DELEGATED REPORT

Application Number: 23/02001/FUL

Proposal: Change of use from dwellinghouse (Use Class C3) to House in Multiple Occupation (Use Class C4). Provision of cycle storage (Retrospective)

Site Address: 187 Divinity Road Oxford Oxfordshire OX4 1LP

Current Bin Storage

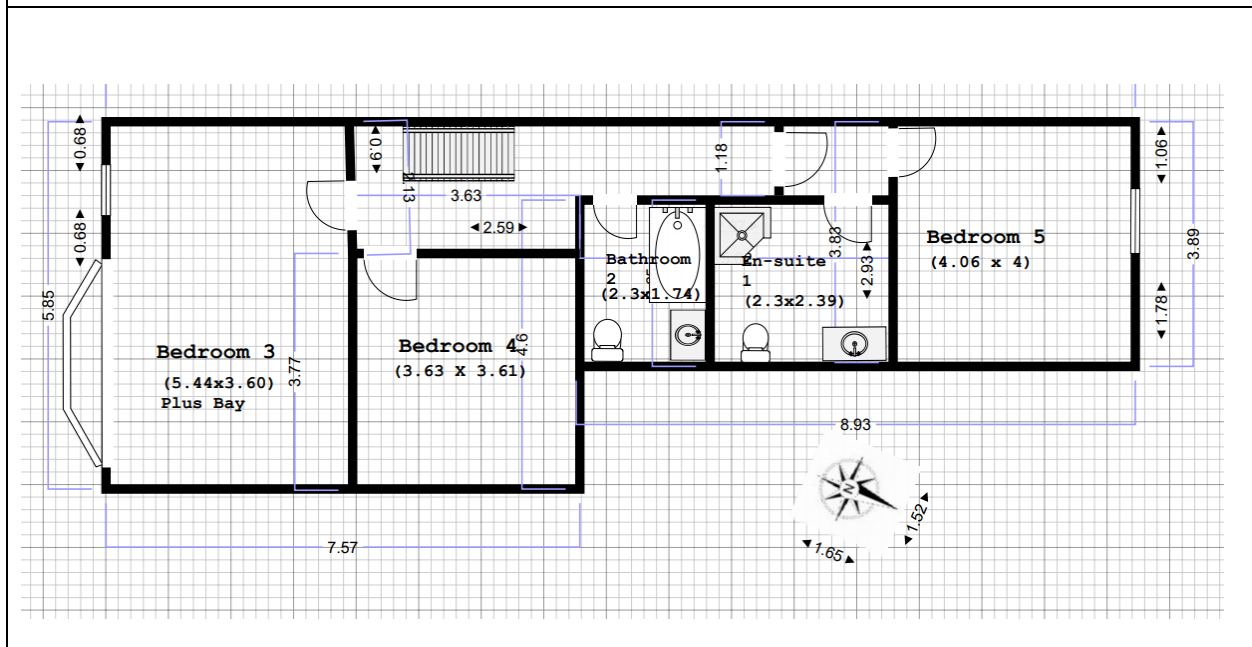
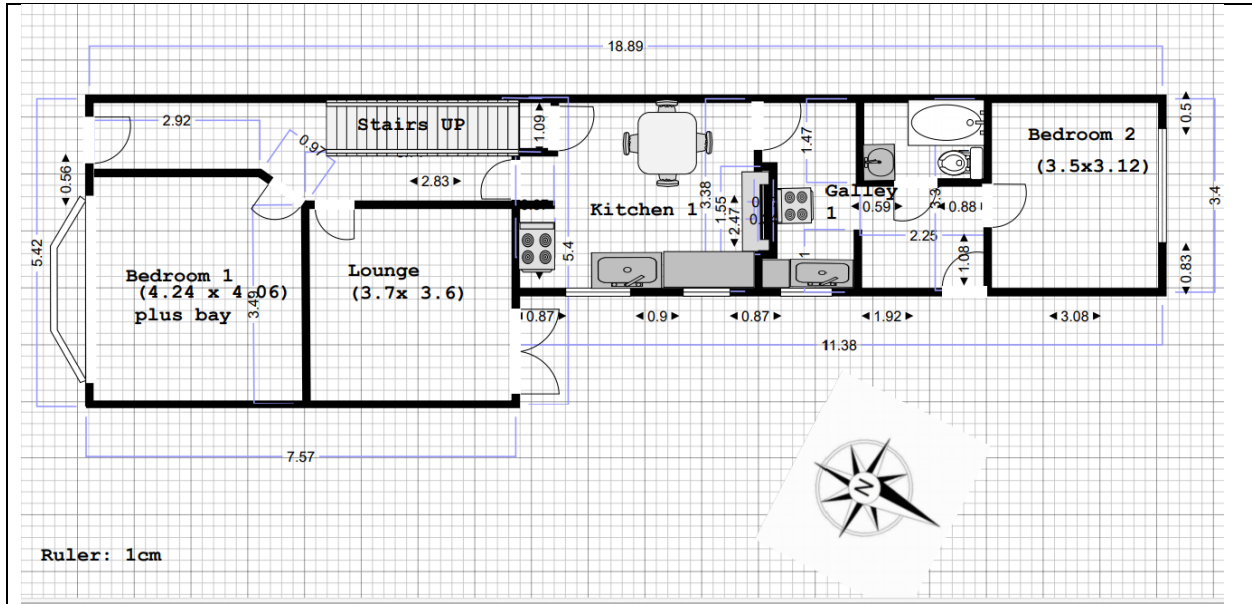
- 2 No details of bin storage have been provided and therefore the proposal fails to make provision for appropriate bin storage. As such, the proposal would fail to meet the requirements of the day to day needs of occupiers and is contrary to Policies DH7, RE7 and H6 of the Oxford Local Plan 2036.

No details on proposed bin storage have been provided as part of this application and therefore the proposal fails to make provision for appropriate bin storage. The use of the property as an HMO means that there may be additional refuse bins required compared with a dwellinghouse occupied by a single household. Officers have considered that there would in some cases be an opportunity to resolve the requirement for a refuse store in the front garden but this cannot be provided by condition as planning permission would be required in order to provide a refuse store that would adequately screen bins (having had regard to the provisions of Part 2, Class A of Schedule 2 of the Town and Country Planning (General Permitted Development) Order 2015 (as amended)). The failure to provide adequate storage of bins can lead to their proliferation in a front garden to the detriment of the amenity of the area or lead to their storage on the public highway to the detriment of highway safety. As such, the proposal would fail to meet the requirements of the day to day needs of occupiers and is contrary to Policies DH7, RE7 and H6 of the Oxford Local Plan 2036. In reaching this view, officers have been mindful of the needs of all road users where refuse bins could impede the highway and this should be carefully considered in the context of both highway safety and the requirements of Section 149 of the Equalities Act (2010) (the Public Sector Equality Duty).

187, Divinity Road, Oxford, Oxfordshire, OX4 1LP

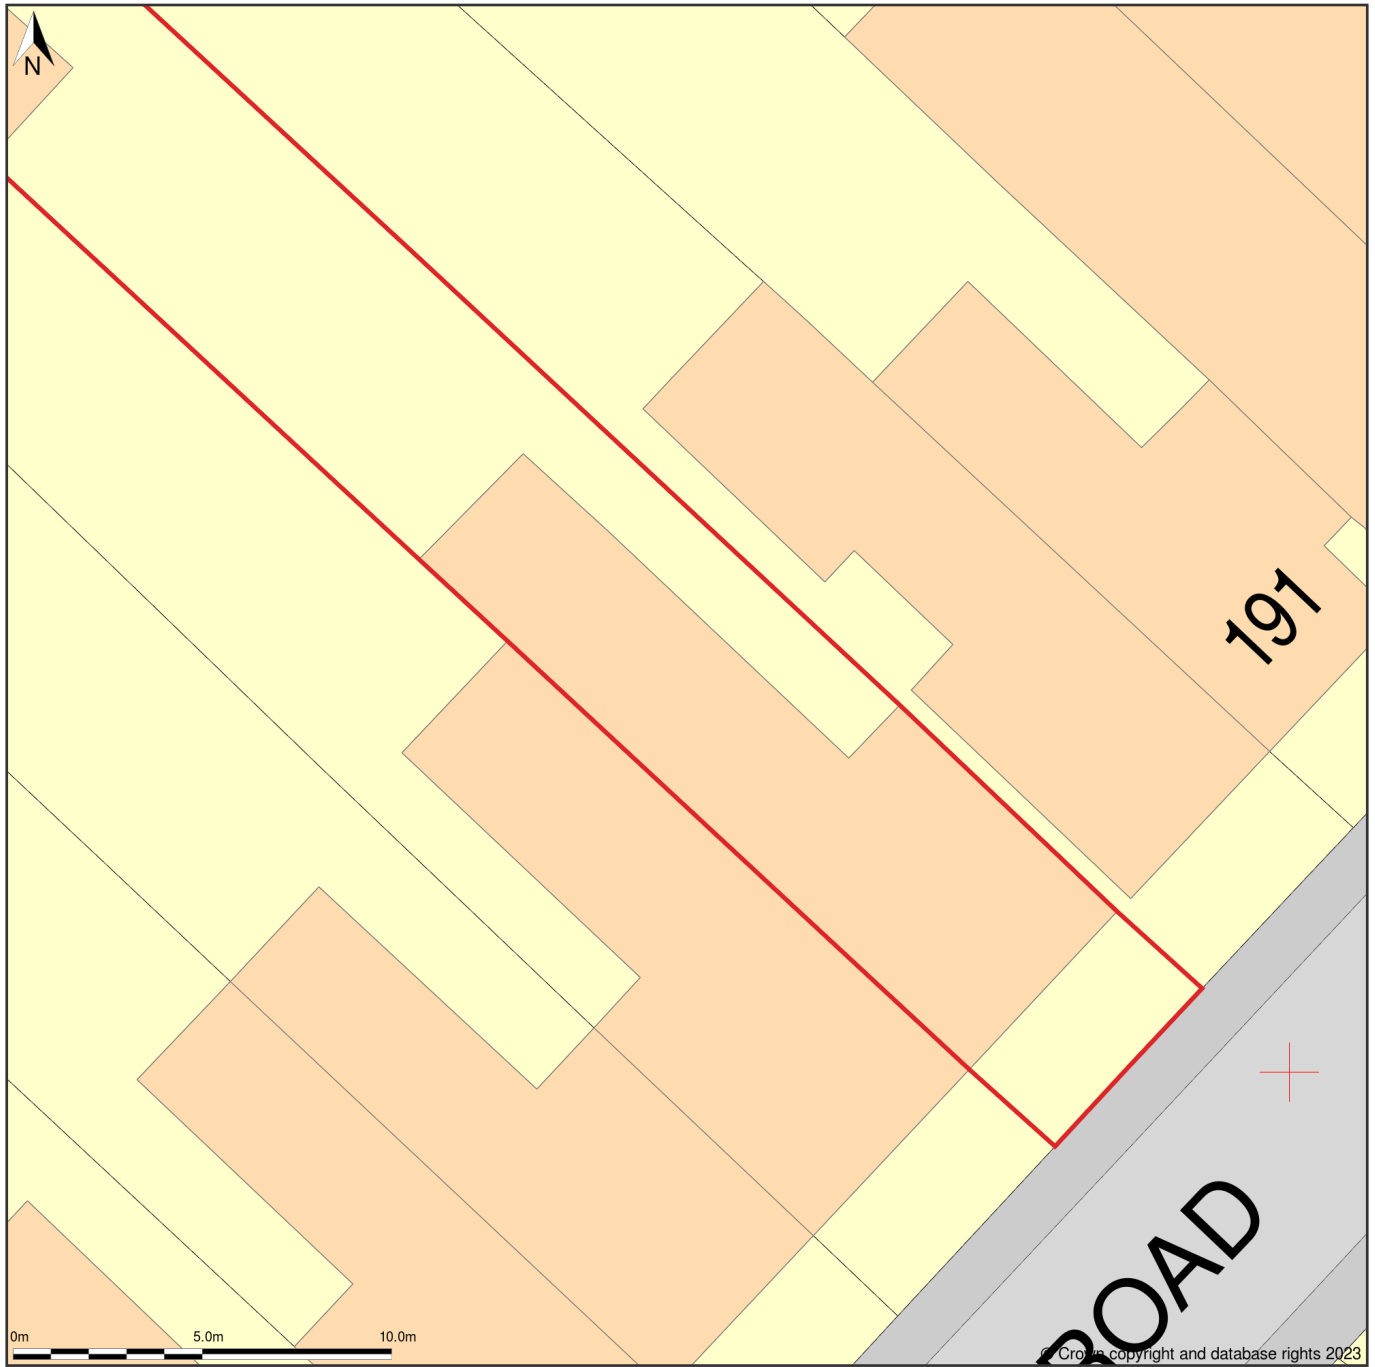
Appendix 7.4 states that the minimum bicycle parking standards for HMOs is at least 1 space per occupant, meaning a minimum requirement of five spaces is required. Limited details of the proposed cycle storage have been provided. The applicant has failed to submit elevational drawings of the cycle storage and no block plan showing the proposed location of the cycle storage has been provided. However, upon the officer carrying out the site visit, the cycle storage had already been implemented, in the form of a shed at the end of the rear garden. Upon further investigation, the shed likely constitutes permitted development and has been in place for a period of 10 years or more, meaning it is likely immune from any enforcement action. The existing cycle storage is secure, covered and enclosed. Whilst the design is not of the highest quality as the shed has deteriorated slightly over time, as it is located in the rear garden, the views of the shed would be very minimal and as mentioned above,

The existing cycle storage provides parking and storage for five bicycles and would therefore meet the minimum requirements outlined in Appendix 7.4. Access is provided from the front to the rear of the property via a shared alleyway between No. 187 and No. 189, which the applicants have declared they have right of access to. The City Council's Technical Advice Note (TAN) on Car and Bicycle Parking advises that access aisles between cycle stands in an enclosed store should be a minimum of 1.1 metre. This is not the same as the proposals which include an alley, but is useful in terms of prescribing a minimum figure where bicycles can be wheeled to access cycle stores. The side access between the properties measures 1.2 metres in width, which although small, on balance, is considered to be suitable for bicycles to be transported via the side access. Therefore, the existing cycle storage is considered to be acceptable in this instance and comply with both Appendix 7.4 and Policy M5 of the Oxford Local Plan 2036. If the overriding reasons for refusal had not been applied, it would have been conditioned for the applicant to provide elevation and block plan drawings of the cycle storage.
